# Meeting note

<b>File reference</b>	BC080001 - London Paramount Resort
<b>Status</b>	<b>FINAL</b>
<b>Author</b>	Robert Ranger
<b>Date</b>	10 November 2015
<b>Meeting with</b>	London Resort Company Holdings
<b>Venue</b>	Site visit start: 11am, Ebbsfleet International Railway Station, 10 November 2015  Meeting: 2pm, Civic Centre, Windmill St, Gravesend, Kent DA12 1AU
<b>Attendees</b>	<i>London Resort Company Holdings (LRCH)</i> Fenlon Dunphy - LRCH Kevin Doyle - LRCH John Letherland - Farrells Richard Hutchings - WSP Alex Lepez - Faithful & Gould Chris Potts - Savills  <i>The Planning Inspectorate (PINS)</i> Susannah Guest Will Spencer Rob Ranger  <i>Local Authorities</i> Peter Price - GBC Sonia Bunn - DBC Liz Shier - KCC Stephen Dukes - KCC Tracey Coleman - EDC
<b>Meeting objectives</b>	Site visit and pre-application project update meeting
<b>Circulation</b>	All attendees

Ref. 6.3.3.2

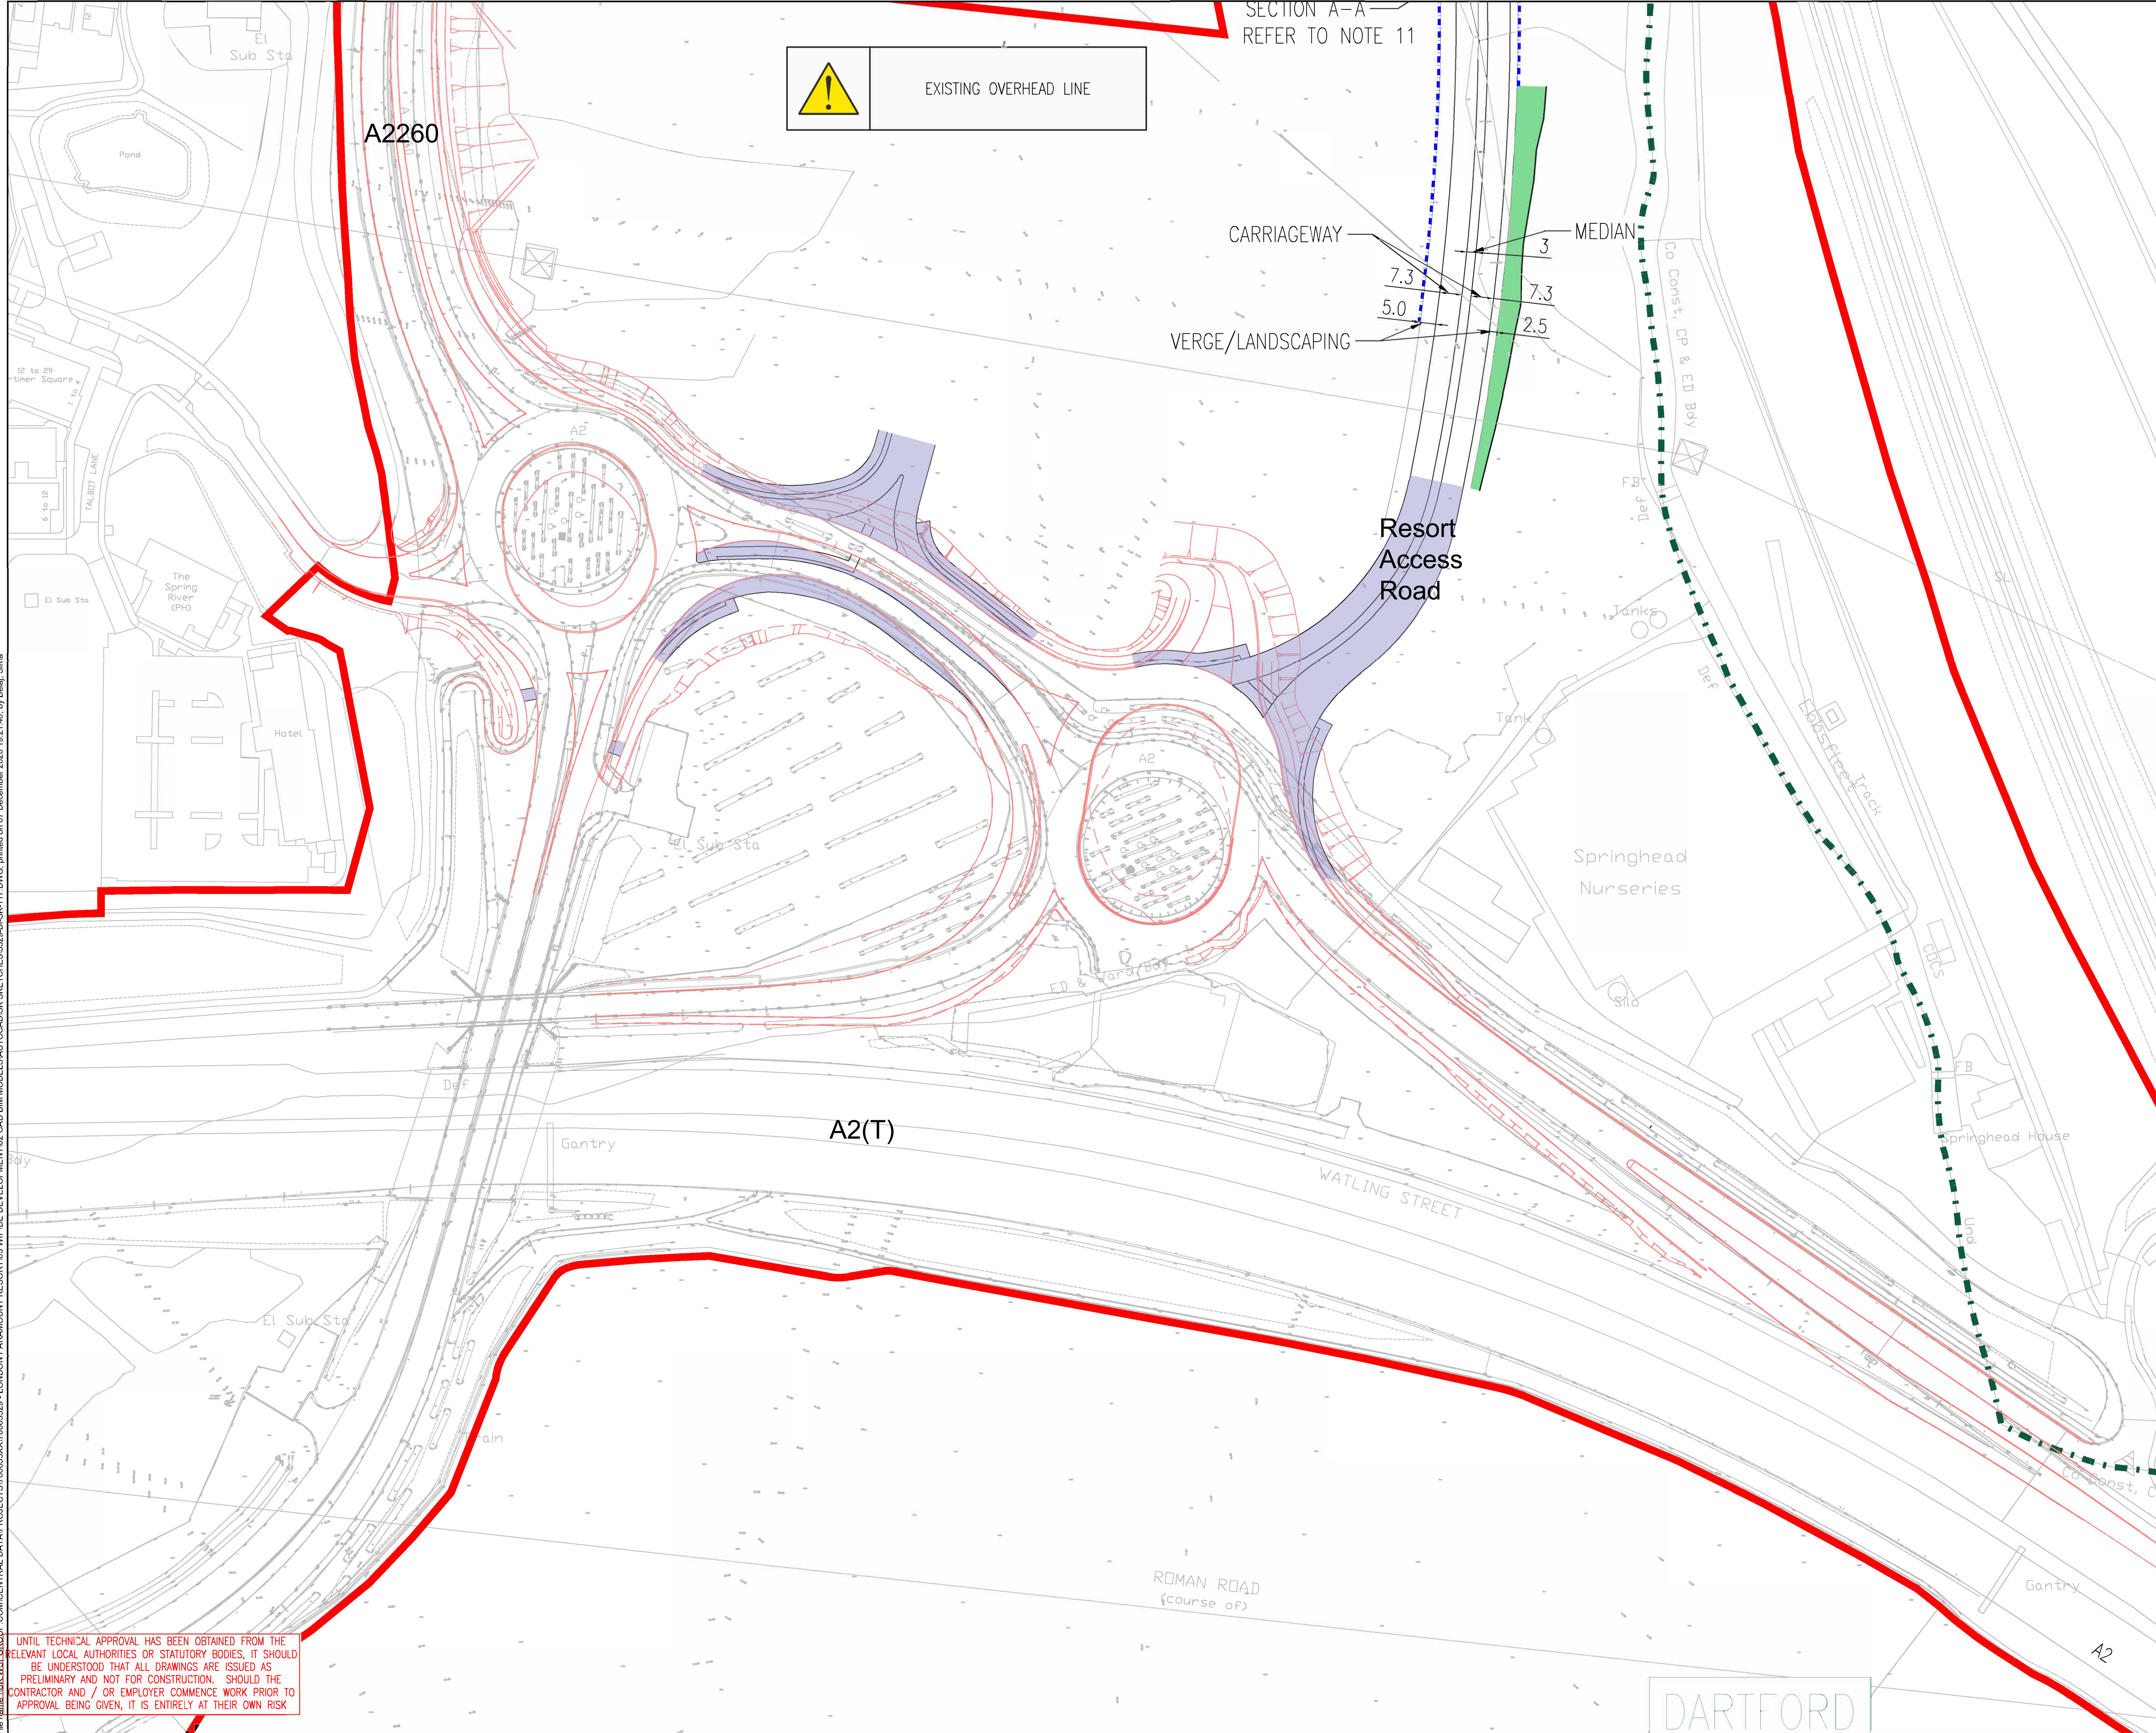
GBC noted that the proposed junction between the resort road and the A2 was actually a junction with (or shared with) the A2260.
